Our Ref: AL/36/20/DOC

Approval of details reserved by condition imposed under ref AL/34/17/HH relating to Condition Nos 3 - materials & finishes and 4 - surface water drainage.

The Studio Tudor Drive Westergate Aldingbourne PO20 3YT

Arun District Council have decided to **REFUSE details reserved by condition for the following reasons:**

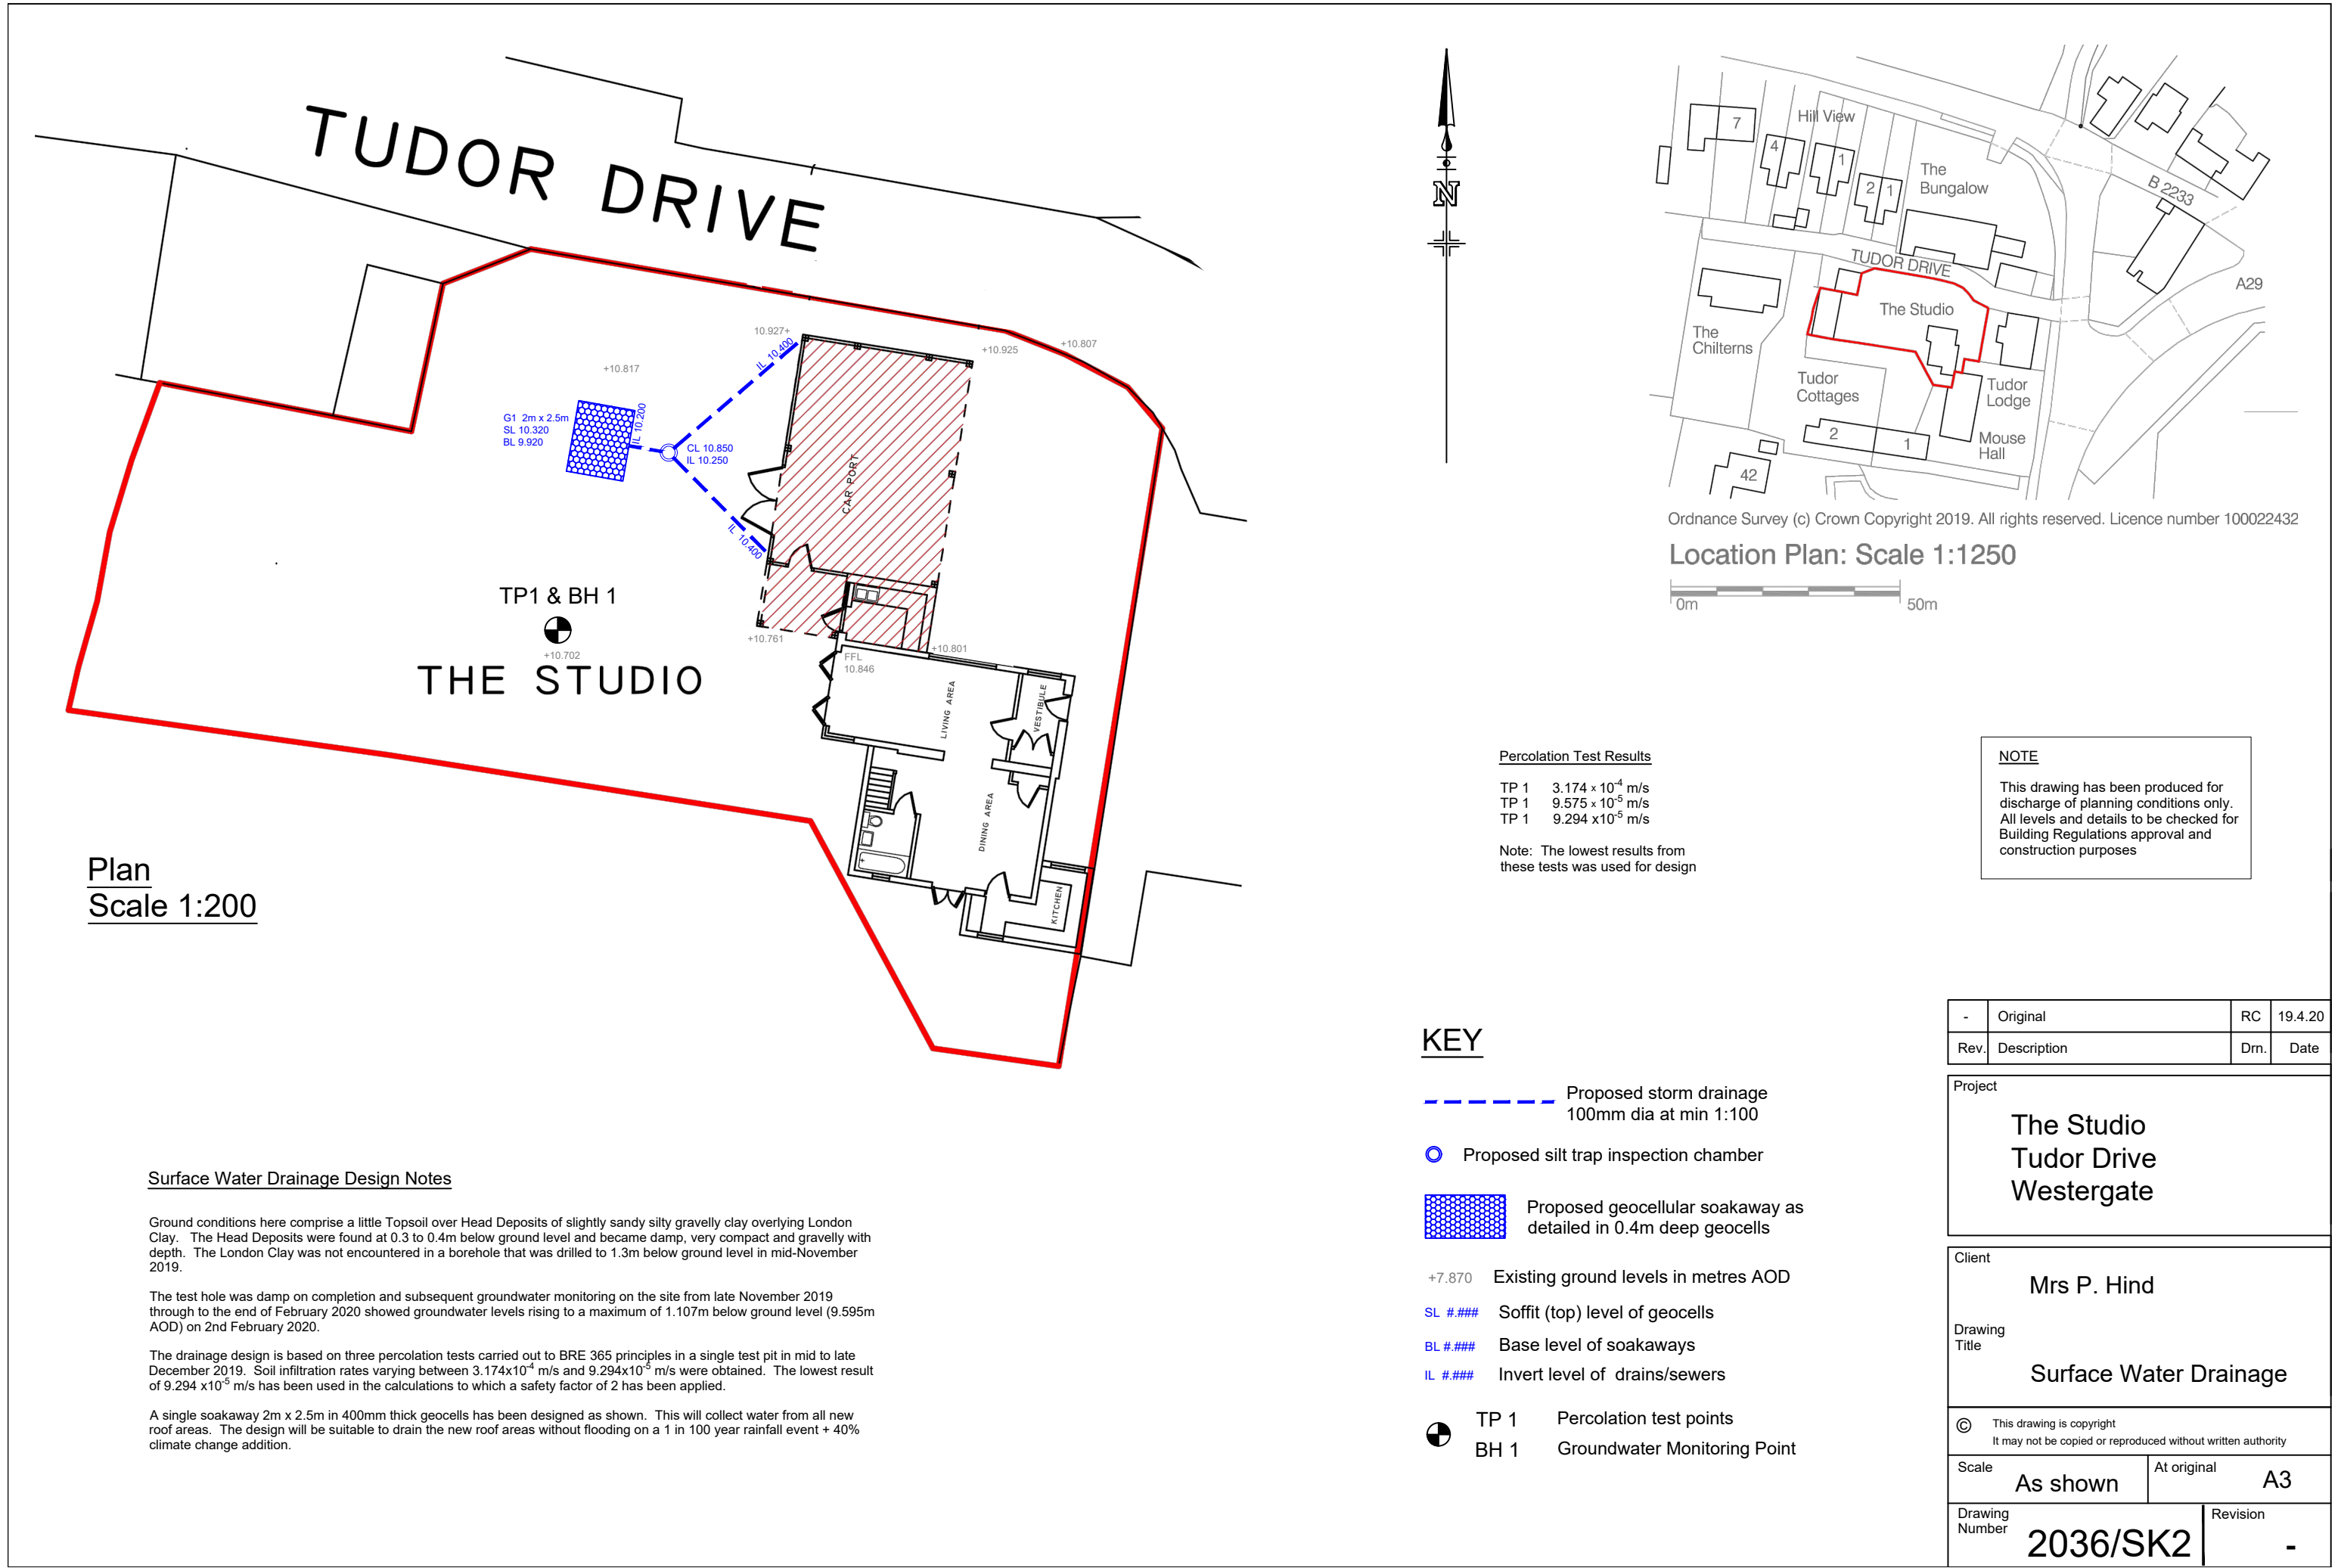
- A construction detail for a concrete pipe bed and surround for where pipe depths are less than 900mm. Plus amend note as to when each surround should be used (Granular where cover to crown is greater than 1200mm in vehicular areas, or greater than 900mm elsewhere. For shallower depths concrete surround.)
- Please confirm the dimensions of the trial pits within the Surface Water Drainage Notes.
